# CITY OF ALBUQUERQUE

July 19, 2004

**Re: Letter dated 7-12-04 re Lyon Strom Drain Project**

STORM DRAIN OPTION #4

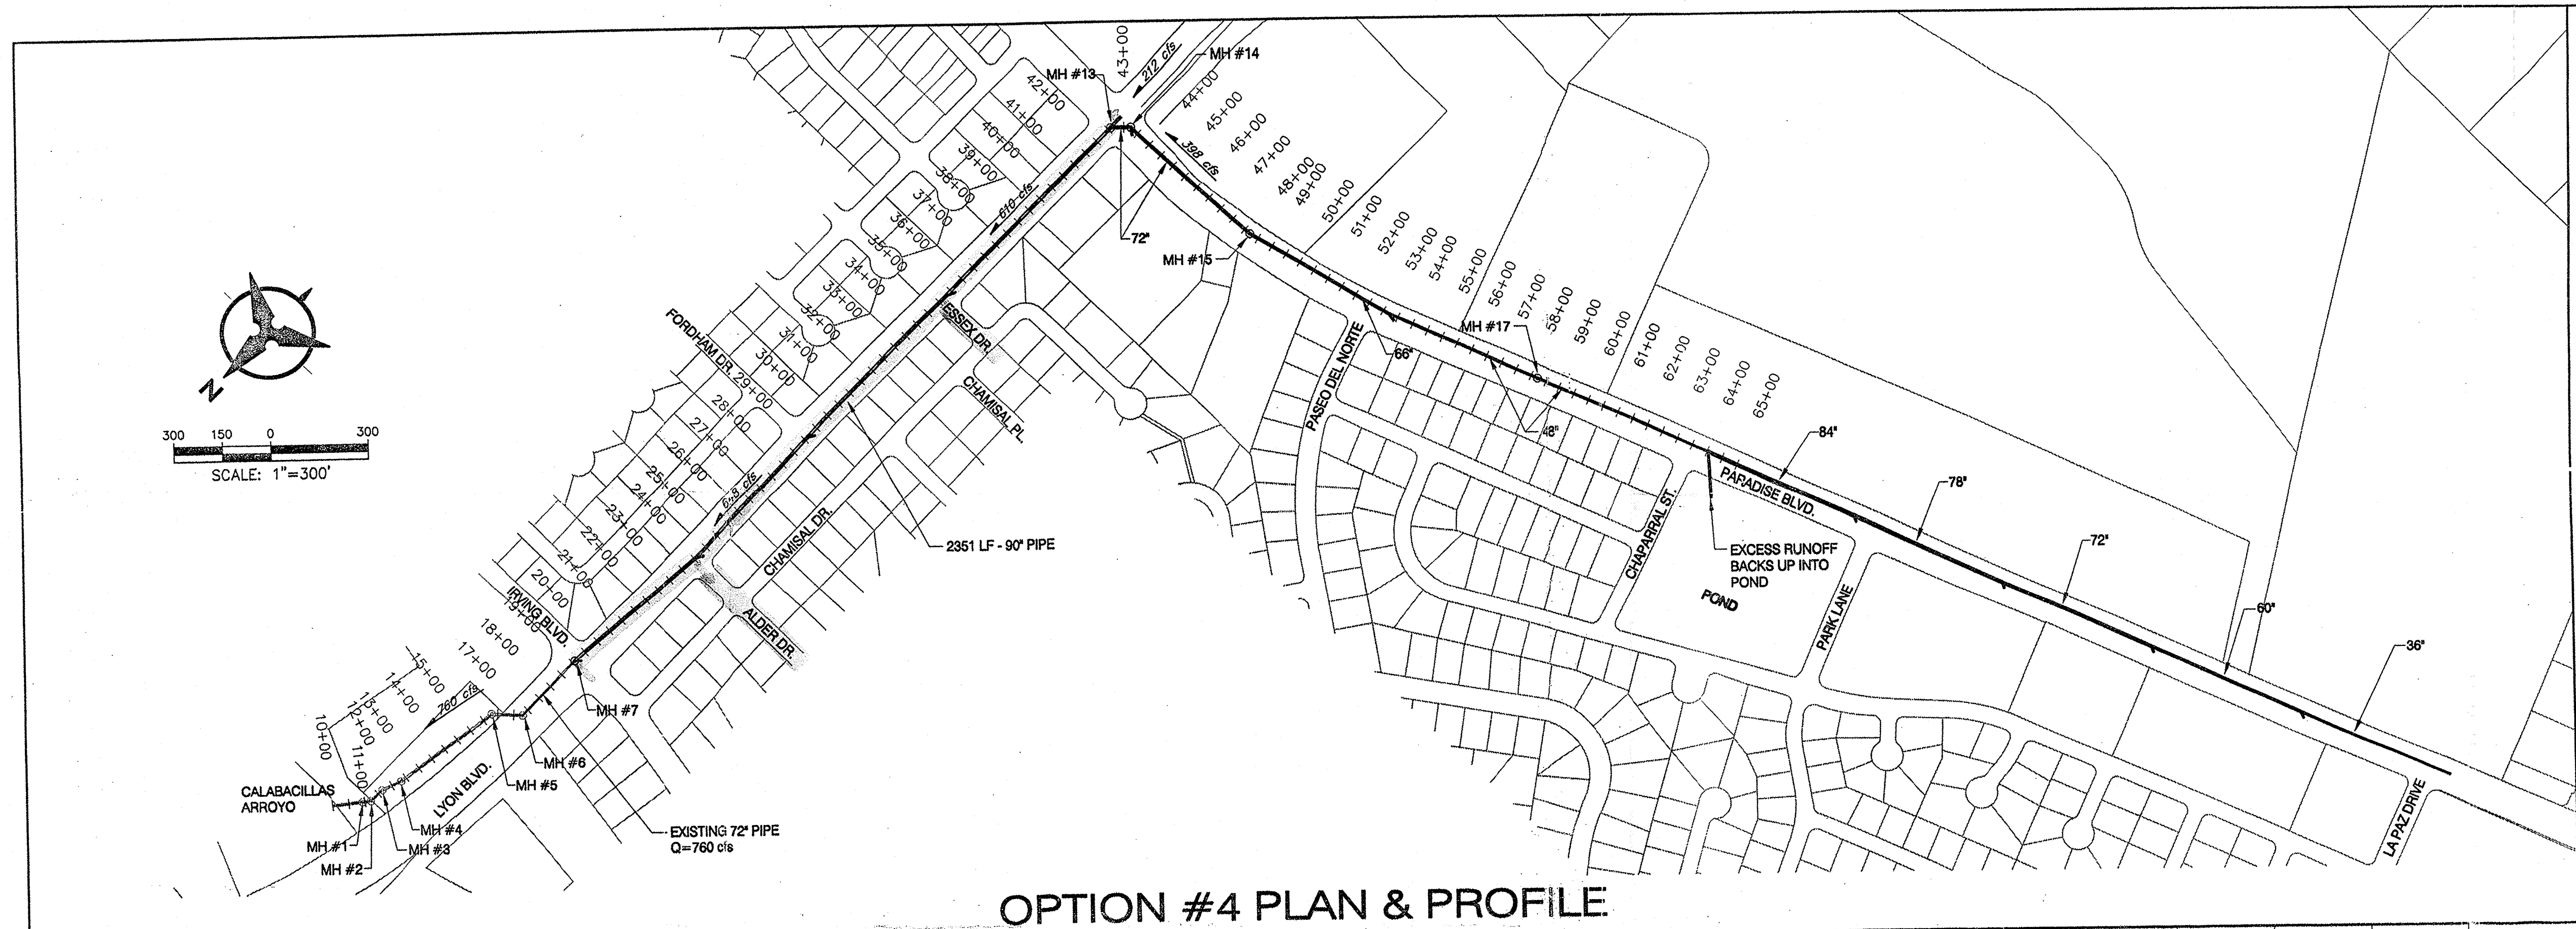
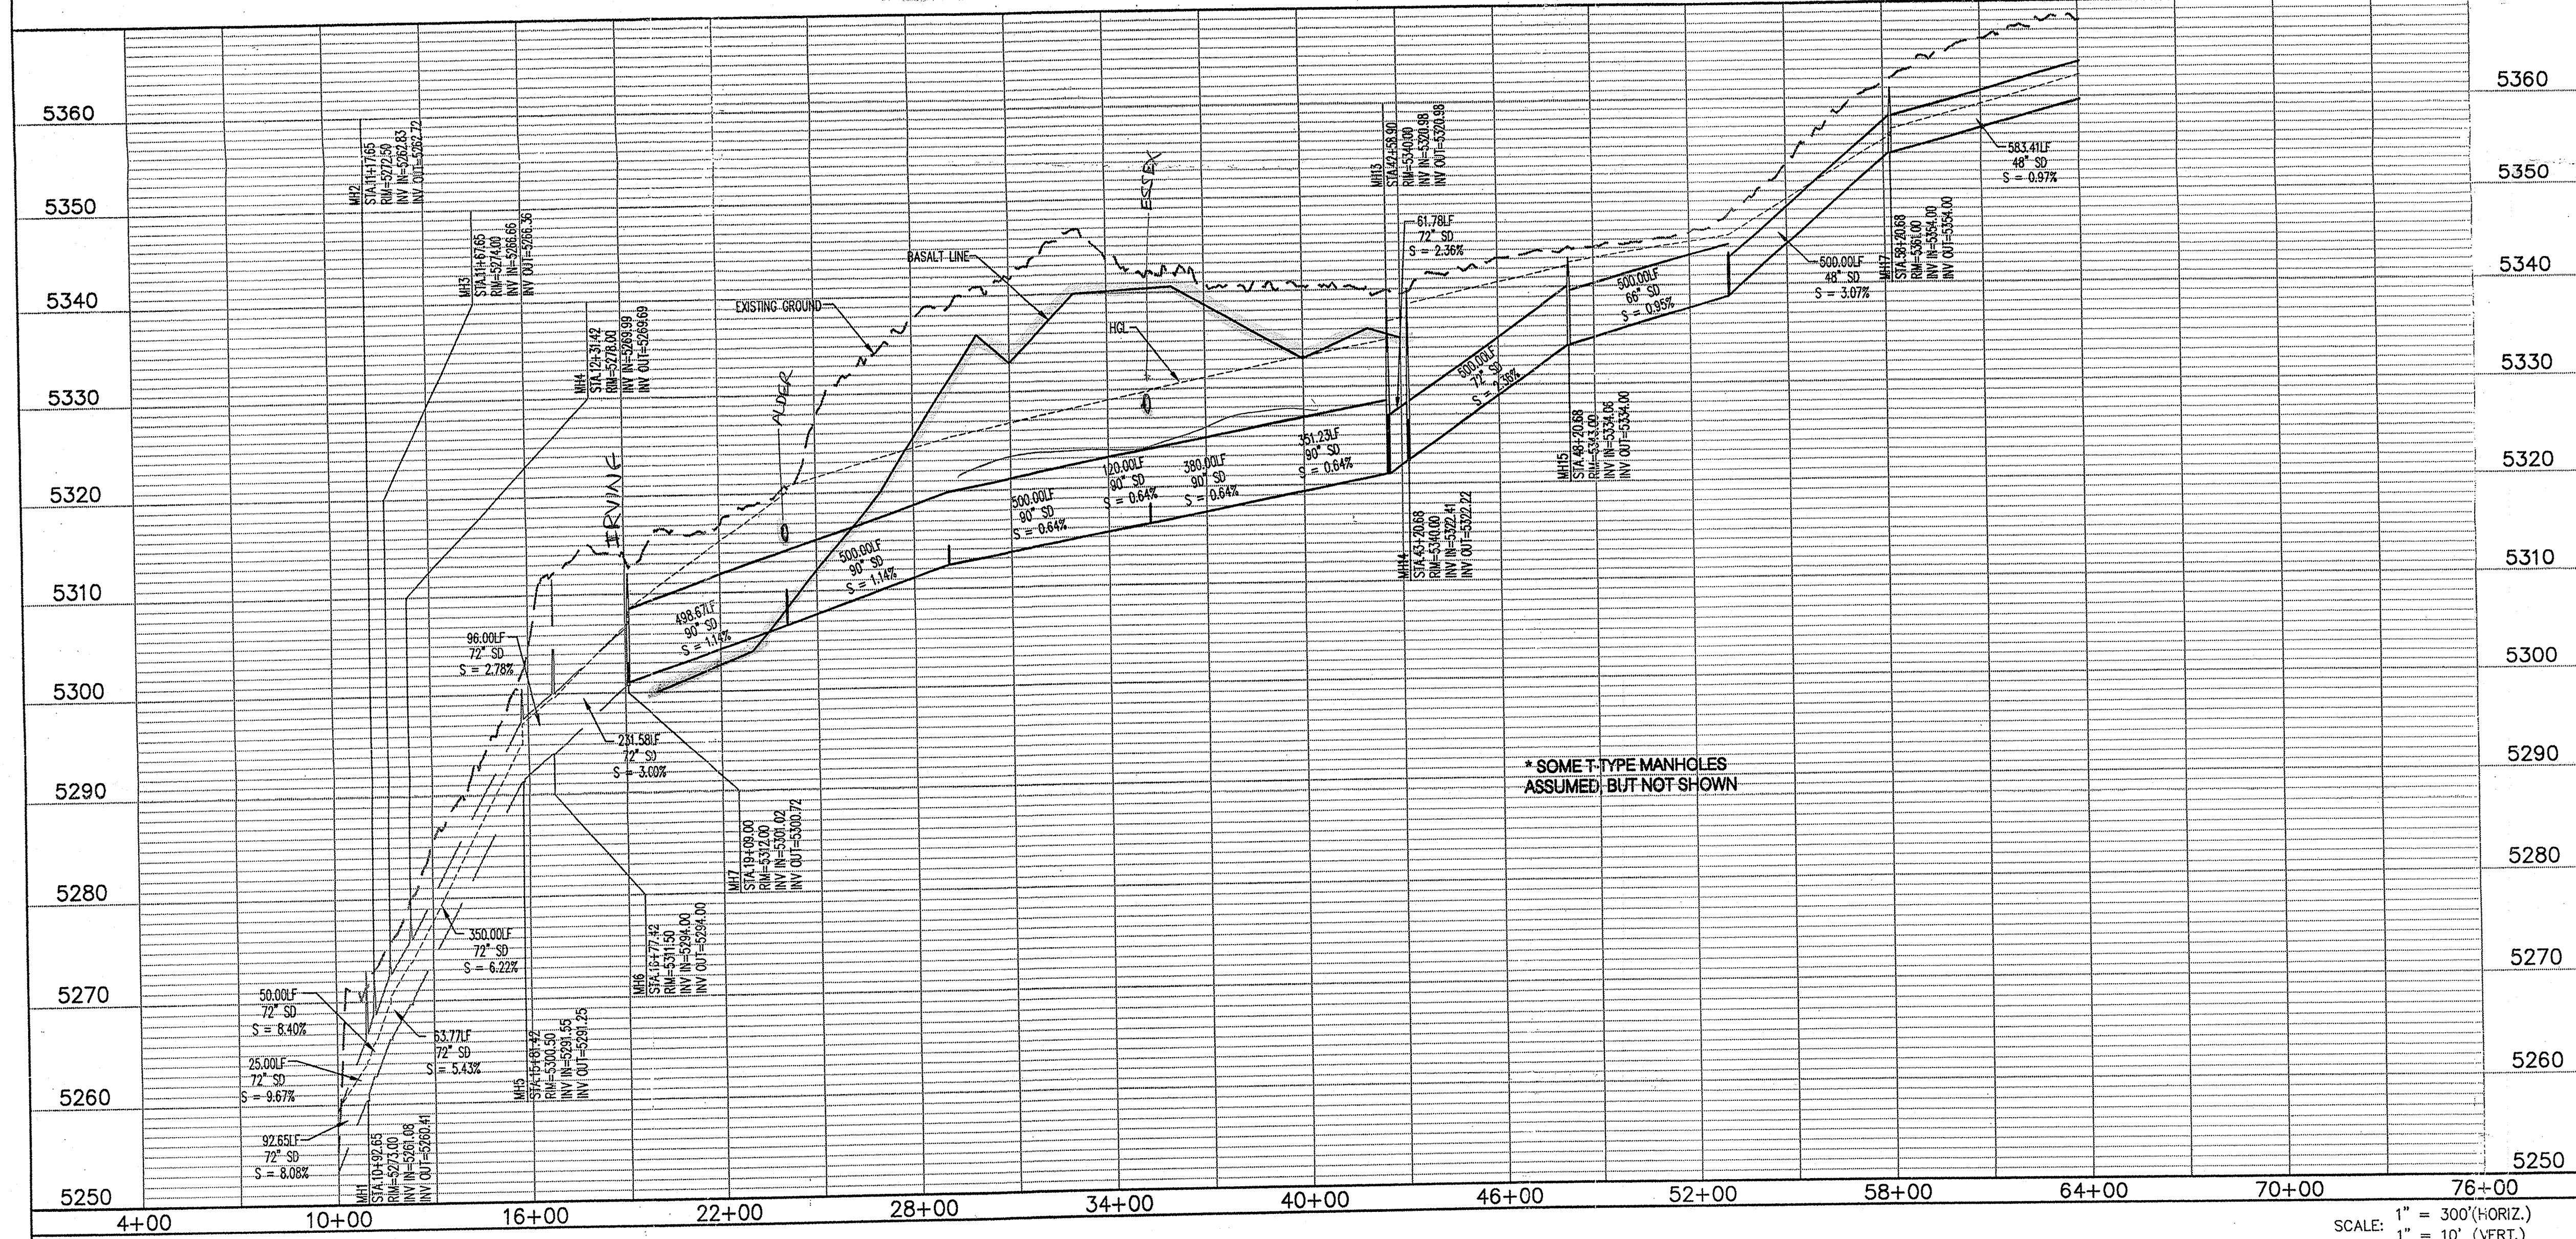
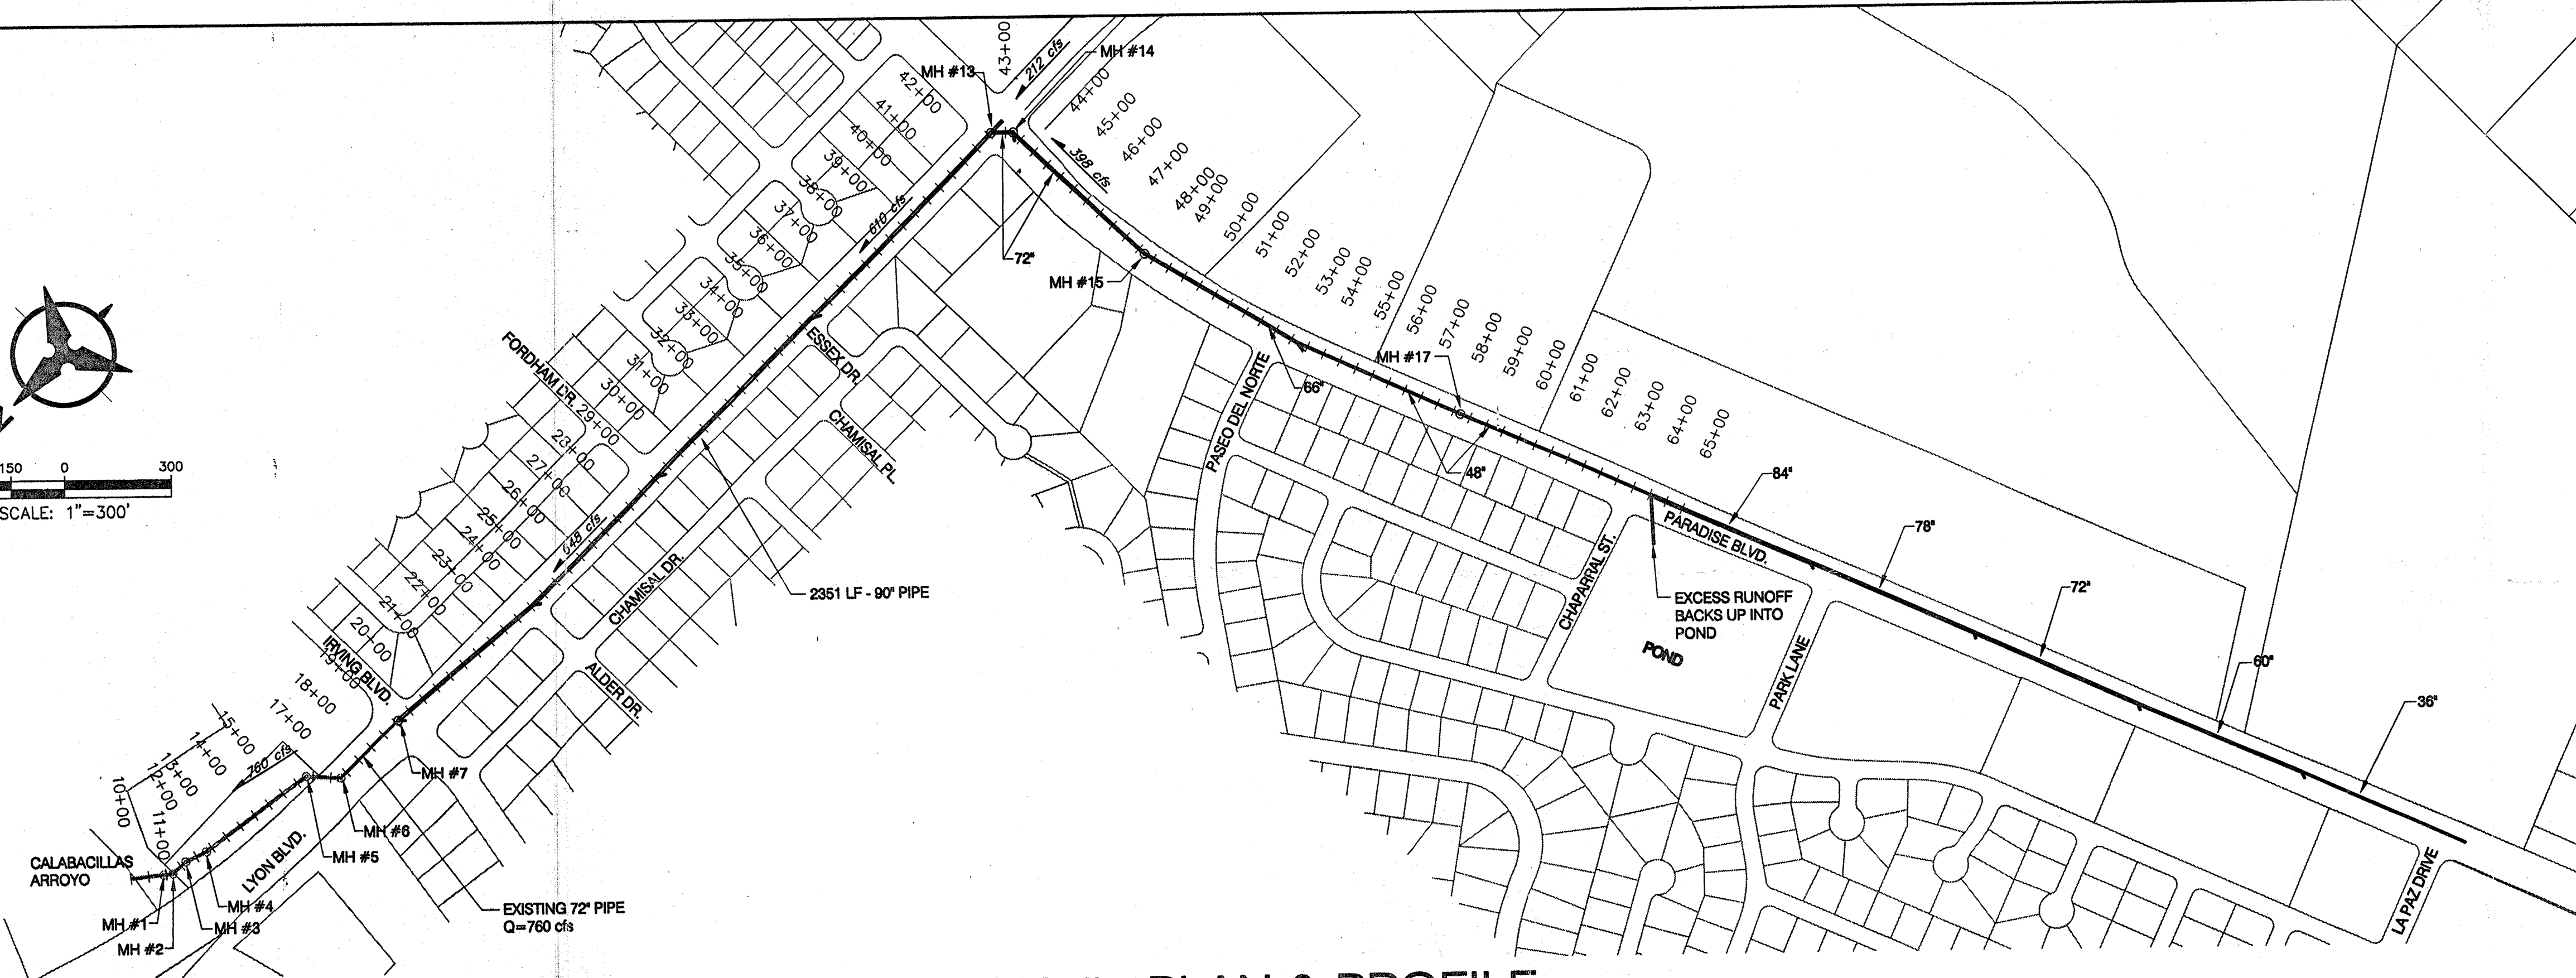
1. Section 22.B.3 of the DPM states that the maximum reduction is 6" and anything beyond that must get City Engineer permission. Before I can grant permission to transition from a new 90" to the existing 72" outlet at Irving, please provide a HGL analysis of the system. It may be necessary to step your transitions in order to keep the HGL below the road.
2. Since this project is providing the ultimate outfall for Paradise Blvd and the full build-out section of Paradise is not built yet, the City will allow a cattle-guard type inlet at Paradise and Lyon to collect existing flows until a future widening project for Paradise is constructed.

1. Section 22, DPM, page 22-102 and 22-103 describes special cases when transitions from Large to Small conduit are allowed. Past studies completed by Bohannon Huston, indicate a need for a 90" diameter pipe tying into a 72" (i.e. 18" pipe diameter reduction) storm drain. Typically, City Engineer approval is required. Will the City approve a transition across a manhole, as long as PLATE 22.3 B-4 is complied with in terms of transition length (L)?
2. Discussions with AMAFCA personnel indicate a desire for a cattle guard inlet, similar to COA STD DWG 2271, at the west leg of Paradise/Unser Intersection. Is this acceptable to the City of Albuquerque?
